Our ref: SV/2021/111161/01-L01
Your ref: TR010056
Date: 14 December 2021

A417 MISSING LINK DCO – ‘RULE 8 LETTER’ - EXAMINING AUTHORITY’S QUESTIONS (EXQ1) – ENVIRONMENT AGENCY RESPONSES

SECTION H - H'  
CH. 5+100 BUSHLEY MUZZARD SSSI

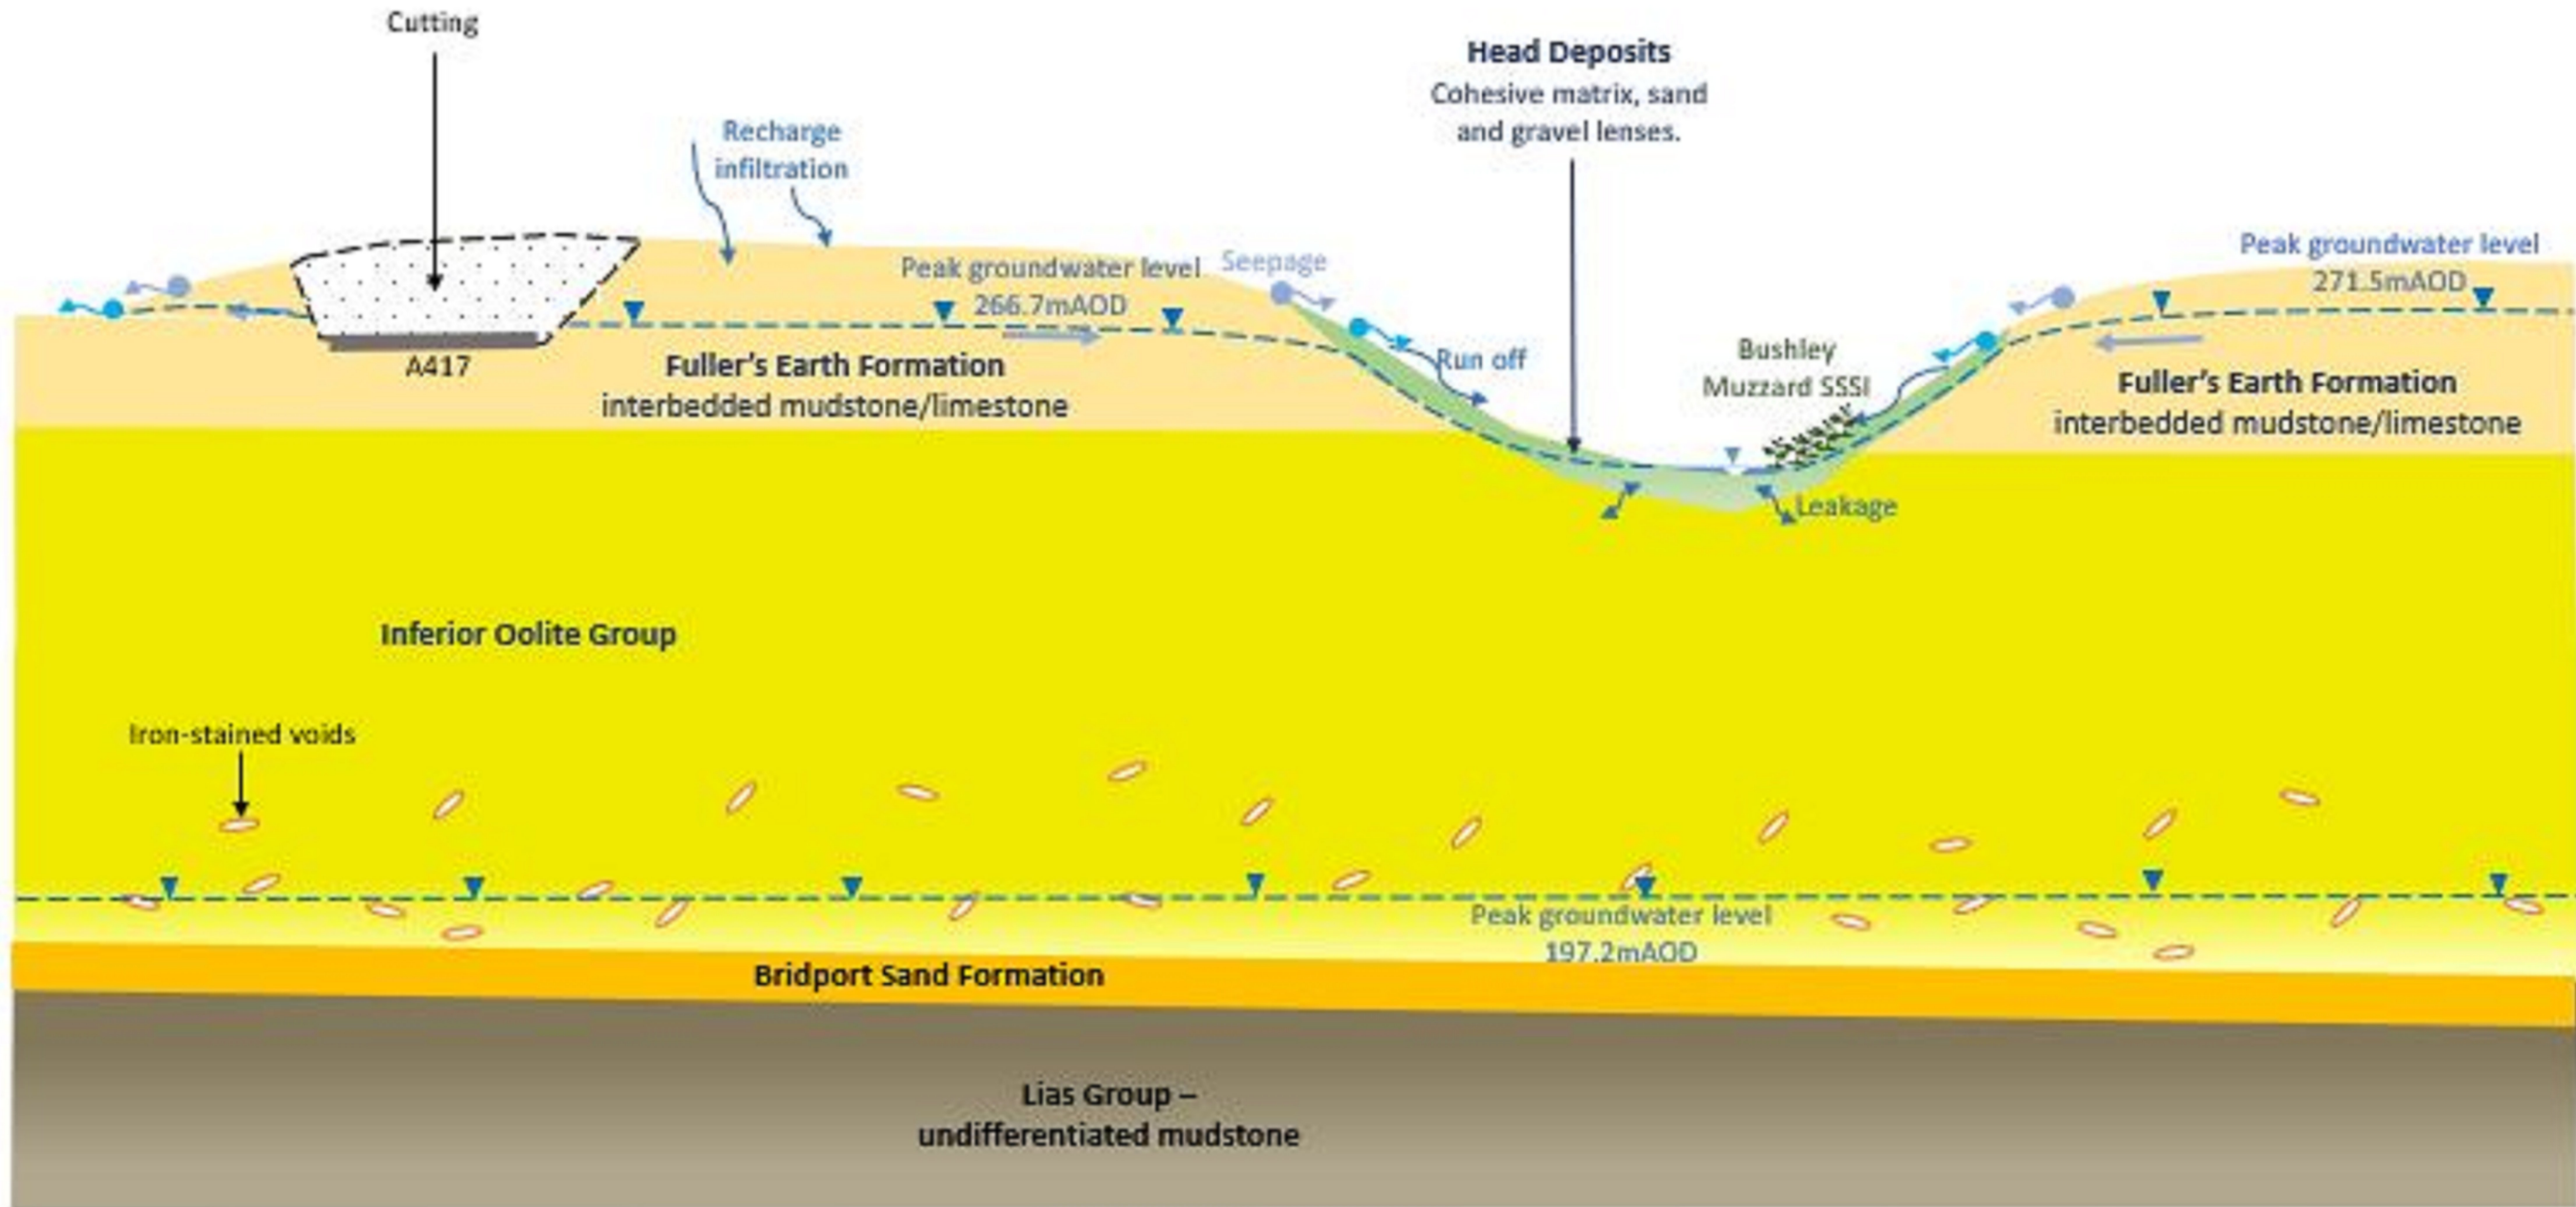
b) What potential effects on the Bushley Buzzard SSSI could occur?

Bushley Muzzard SSSI is an important wetland feature (also called a GWDTE or Groundwater Dependent Terrestrial Ecosystem) which relies on groundwater discharging from springs out of

<p>the local rocks which then support the flows into the local streams which head directly into the headwaters of the River Frome which flows towards Stroud in the south. These springs emanate mainly from more shallow Cotswold Jurassic Limestone aquifers (at the contact between the Great Oolite and Fullers Earth) to the west of the SSSI. It has been identified that the proposed new road is off to the north east from this location. So it is therefore unlikely that the road will have any influence over this important wetland feature due to the distance and being outside of the catchment zone supporting the recharge to the Bushley Muzzard springs. Continued groundwater and surface water monitoring is required to verify that this will be the case.</p> <p>The consultants acting on behalf of NH have undertaken an assessment of the Bushley Muzzard SSSI wetland in relation to the road scheme (ES Appendix 13.8 GWDTEs Assessment) and concluded that it is considered that the scheme does not pose a risk to the identified or potential GWDTEs and no further assessment is required. The conceptual model demonstrates there is no linkage between the potential impacts from the road to groundwater levels and the GWDTE and the Hydrogeological Impact Assessment also supported this conclusion.</p> <p>Surface and groundwater monitoring will still be used to validate the conclusions of this assessment and we are satisfied with this approach.</p> <p>c)</p> <p>We are satisfied with the modelling approach undertaken and after full consultation with NH and their consultants we all agreed to the approach adopted as detailed within the Hydrogeological Impact Assessment.</p>
